Our ref: Q210286/EL
Your ref: PP-12108332
Email: lucas.fallon@quod.com
Date: 04.05.23

Axis J9, Phase 3 – Application for Non-Material Amendment

On behalf of Albion Land (“the Applicant”), please find enclosed an application for a non-material amendment to planning permission 21/03177/F at Axis J9 (“the Site”). The application seeks to vary the list of approved plans set out in Condition 2 to alter Unit 4’s loading door arrangements to accommodate the operations of tenants.

Drawing Title:  
UNIT 4 FLOOR PLANS

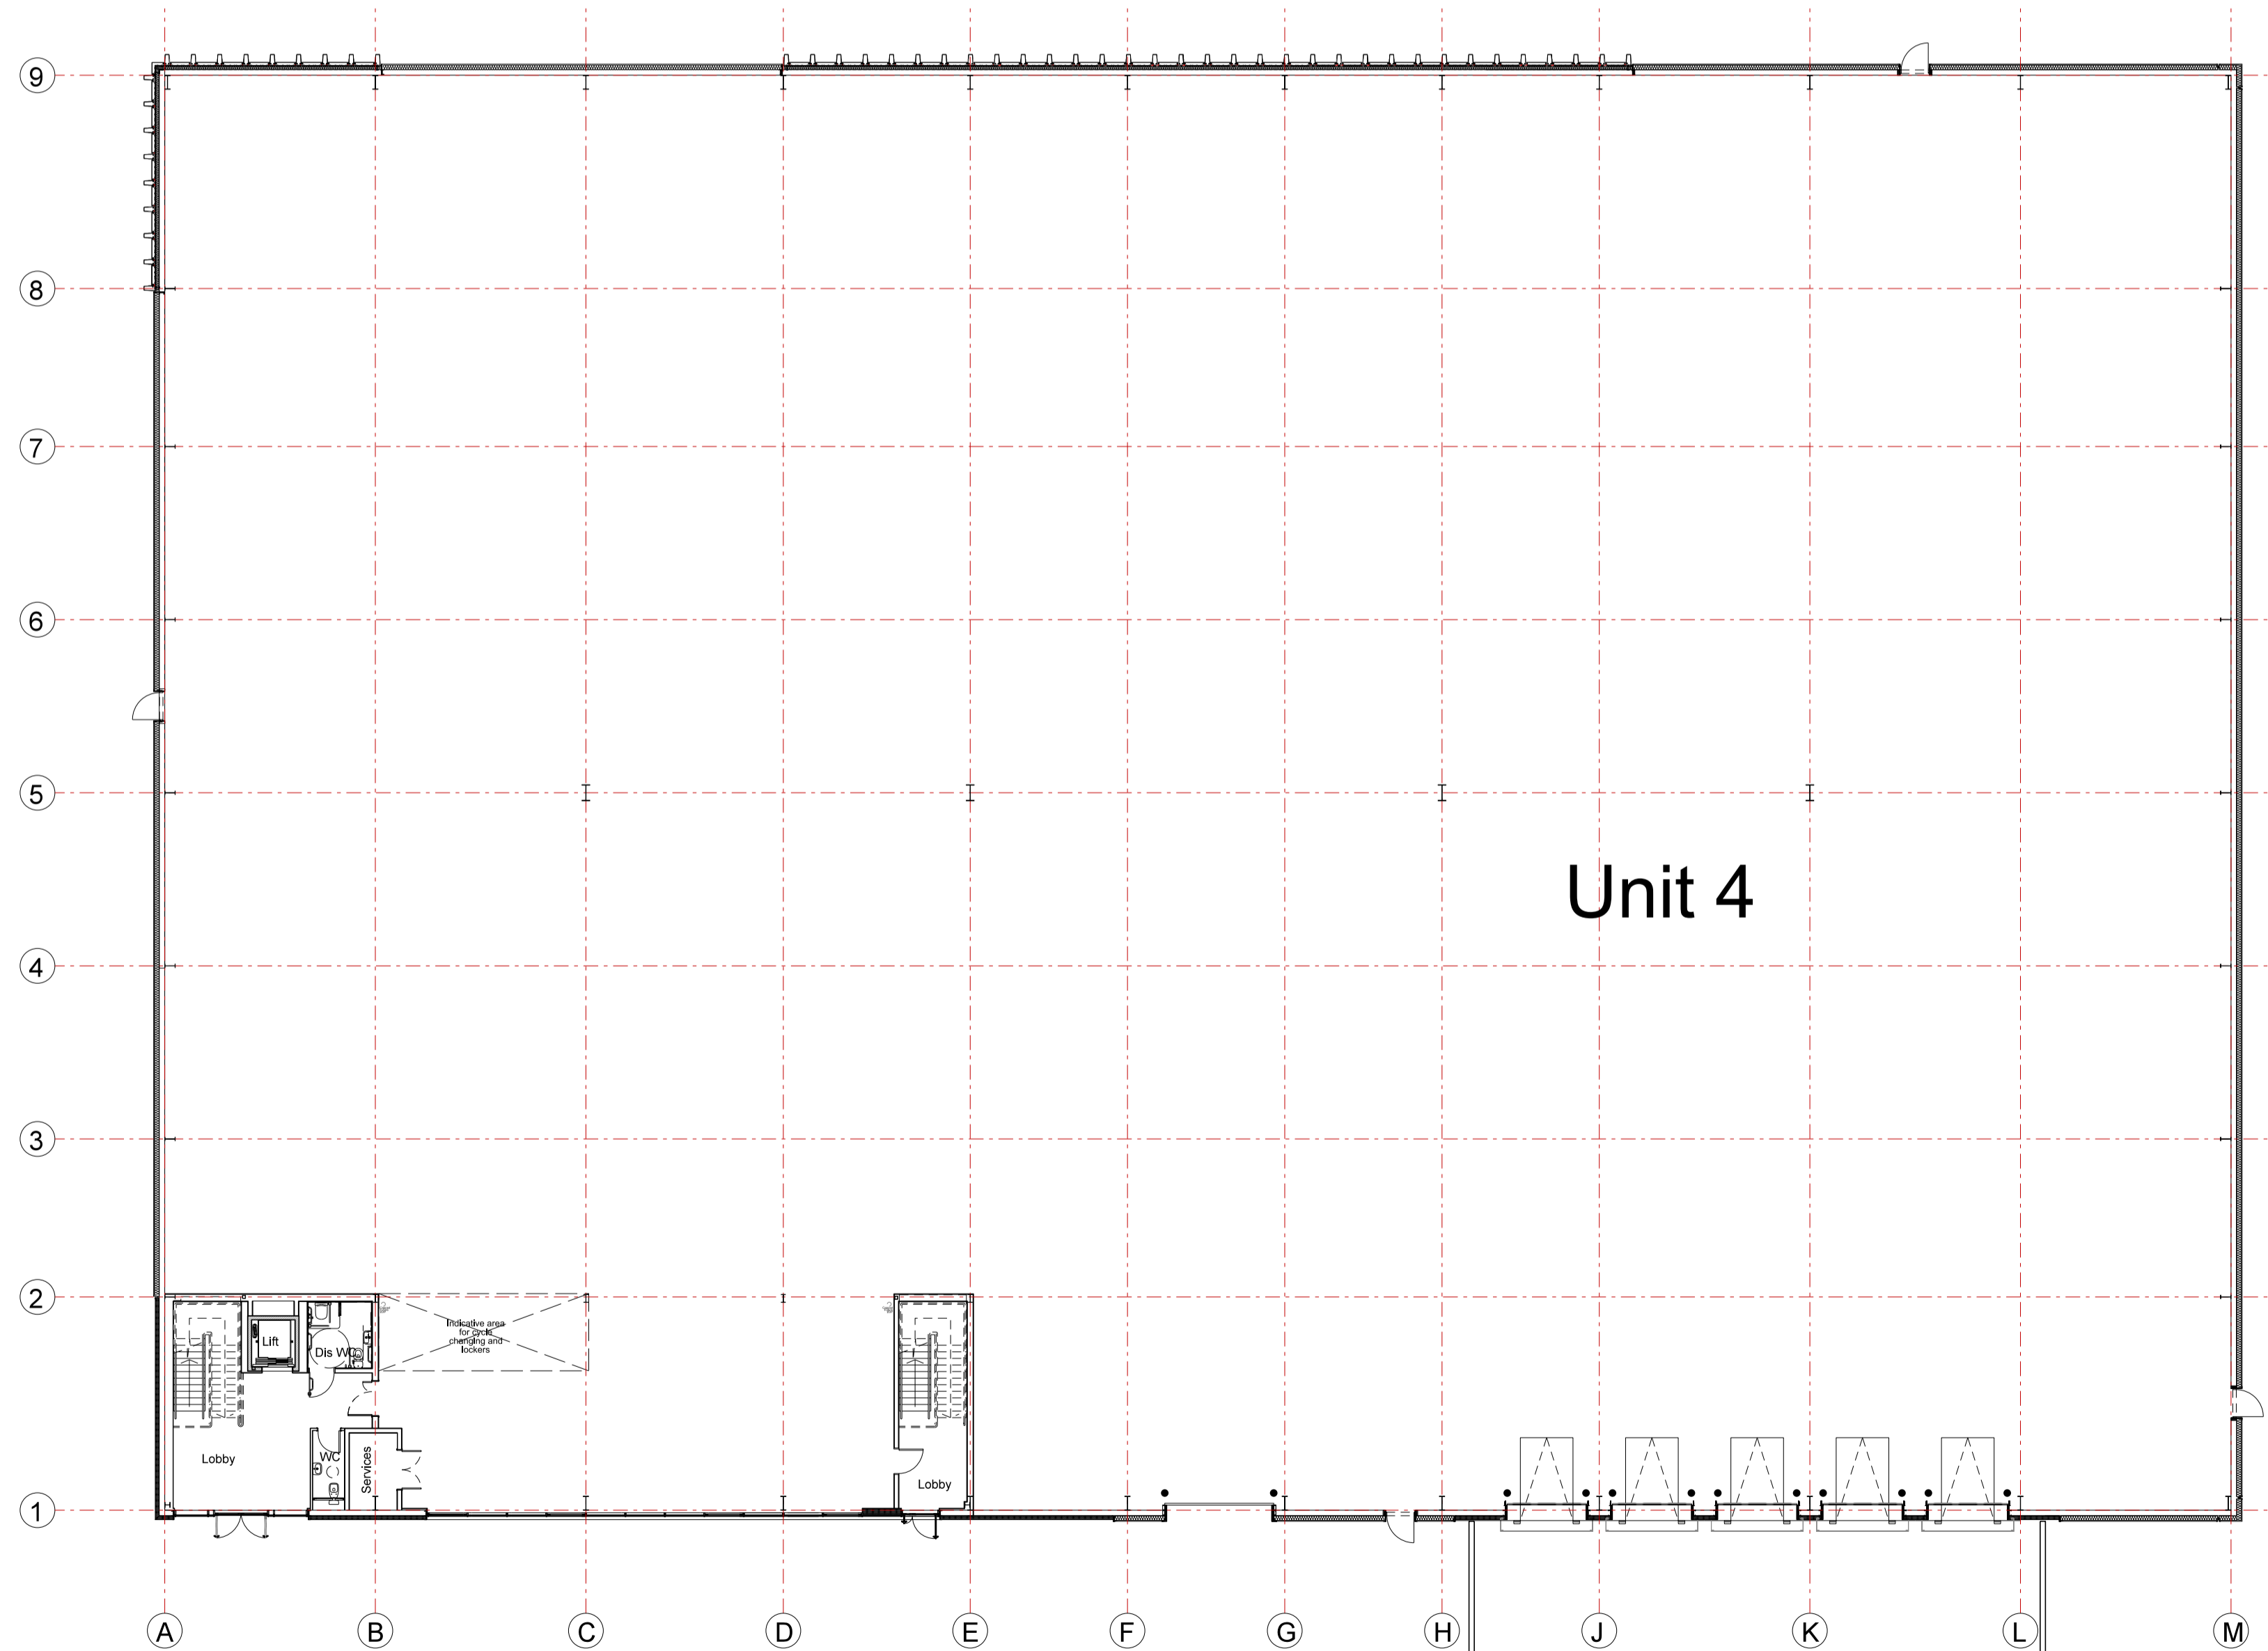
The approved 20019-TP-002 Rev R 'Proposed Site Plan', 20019-TP-003 Rev L 'Proposed Site Finishes Plan', 20019-TP-009 Rev C 'Unit 4 Floor Plans' and 20019-TP-012 Rev D 'Unit 4 Elevations' identify the layout of Unit 4, including its respective service yard. The approved plans outline three level loading and two docks. It is proposed to increase the level loading to five in total and include one level access door.

Drawing Title:
UNIT 4 ELEVATIONS

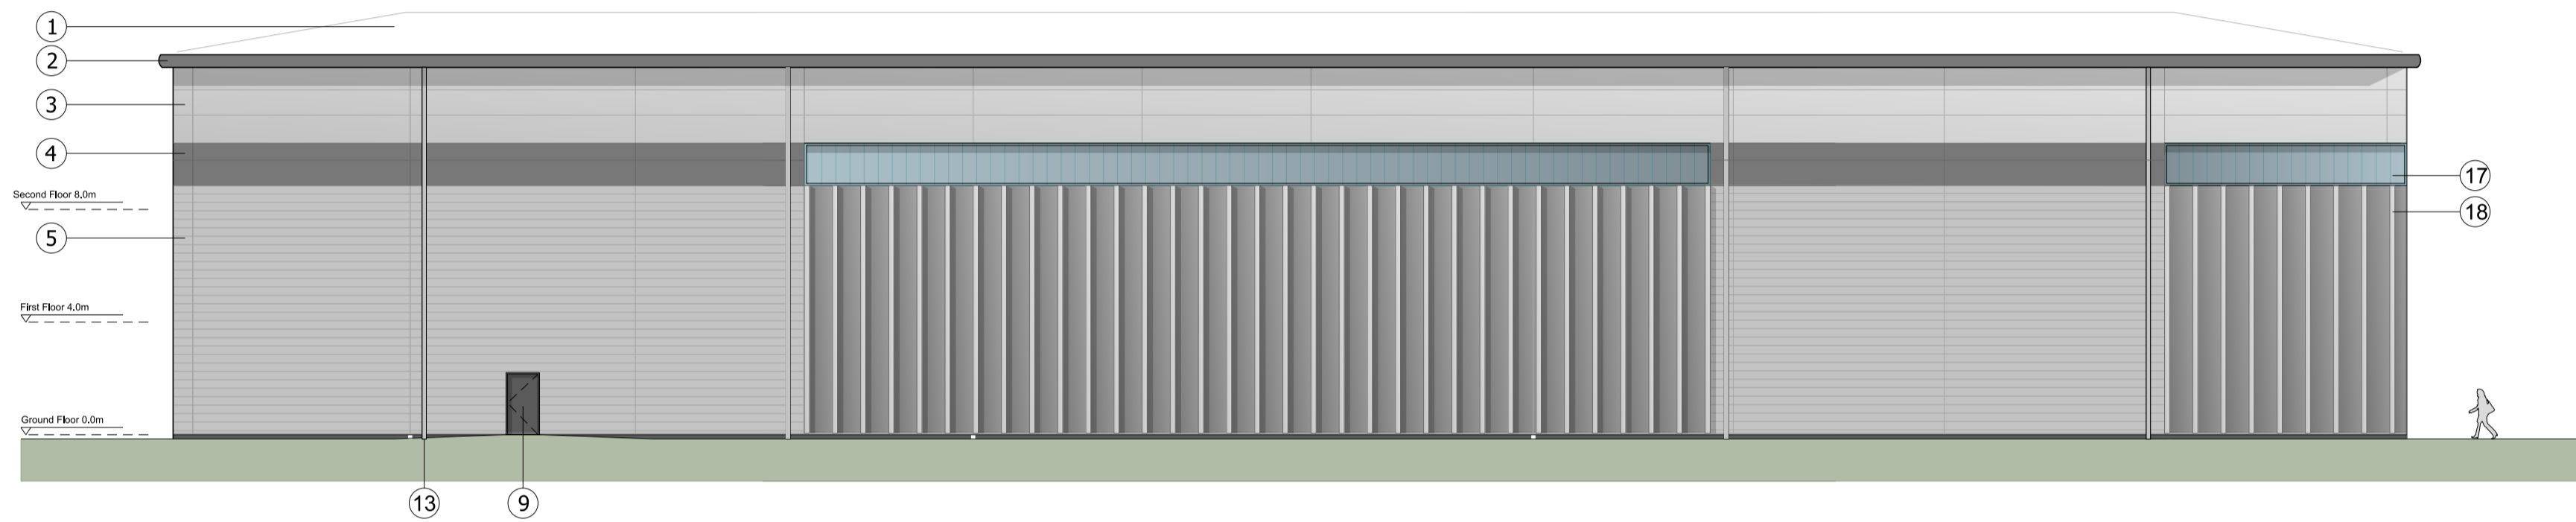
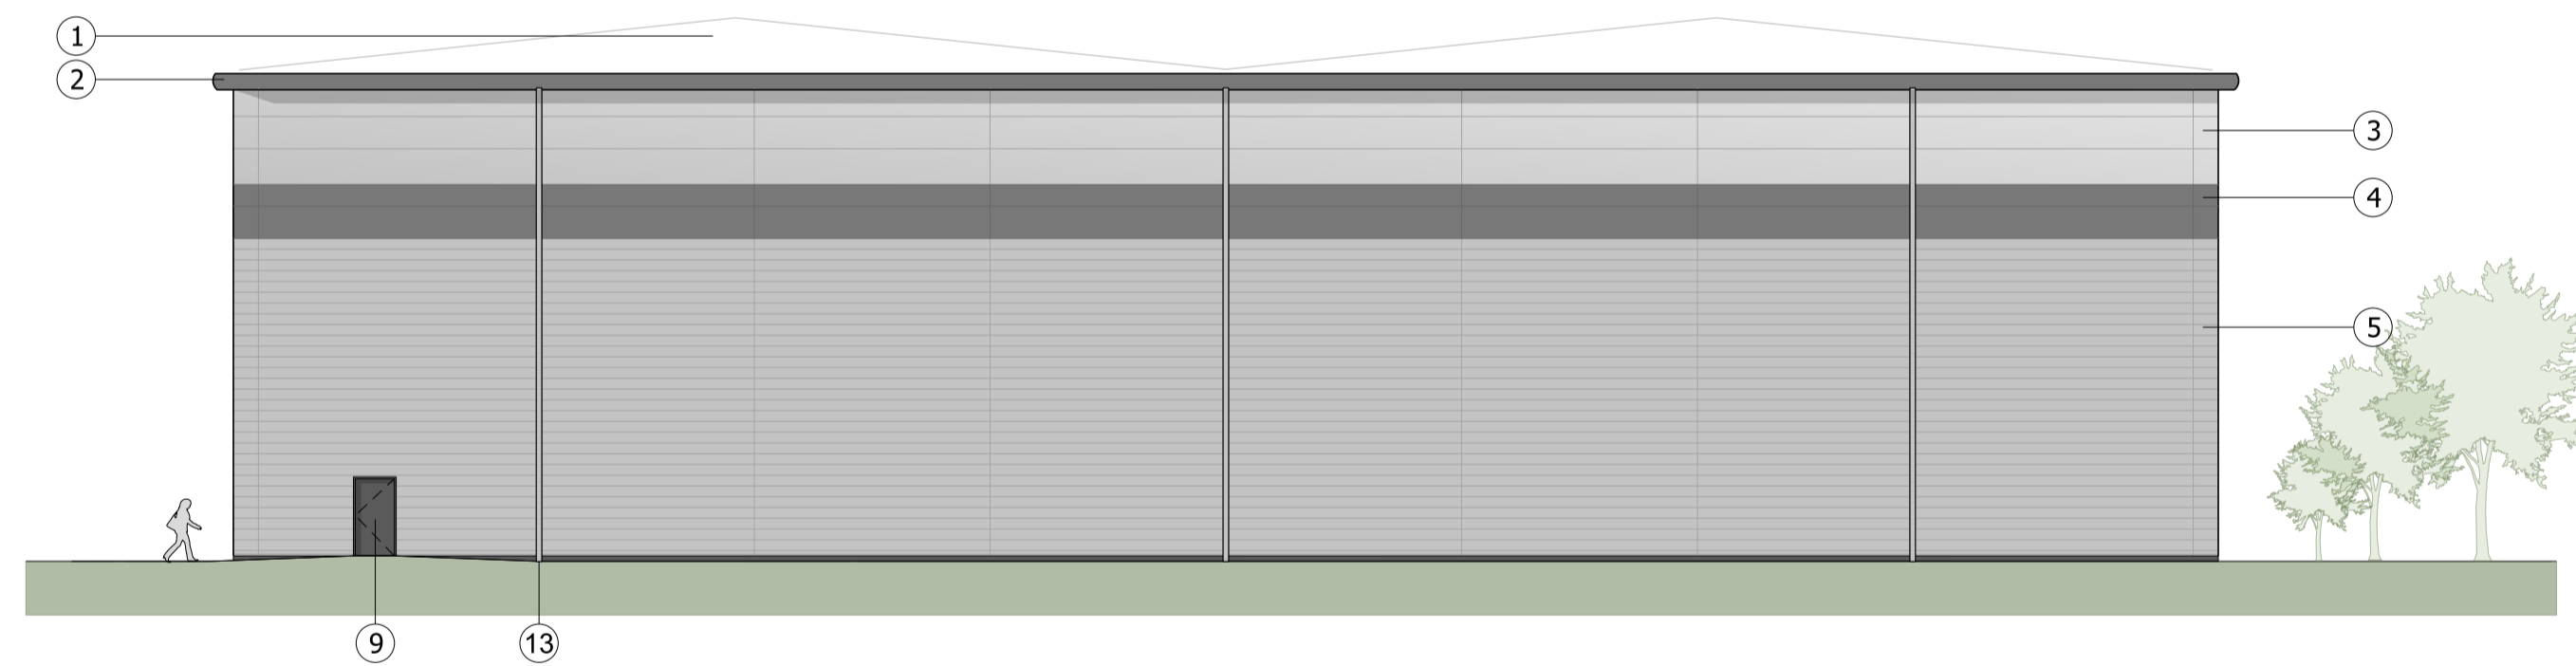
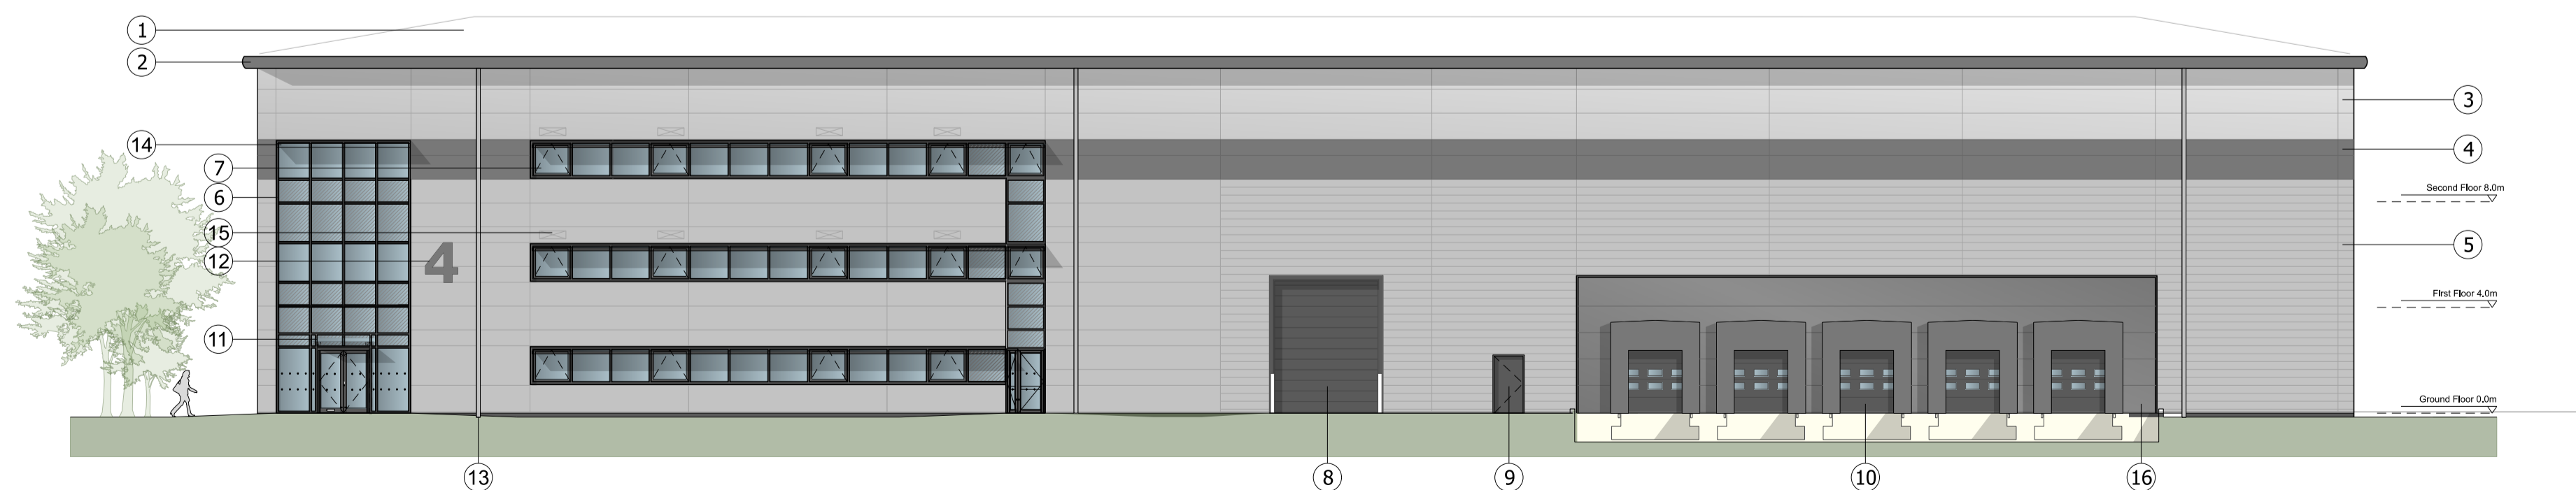
The proposed change is a minor modification of the servicing arrangements, which have resulted in minor changes to one external elevation and the layout of the yard respectively.
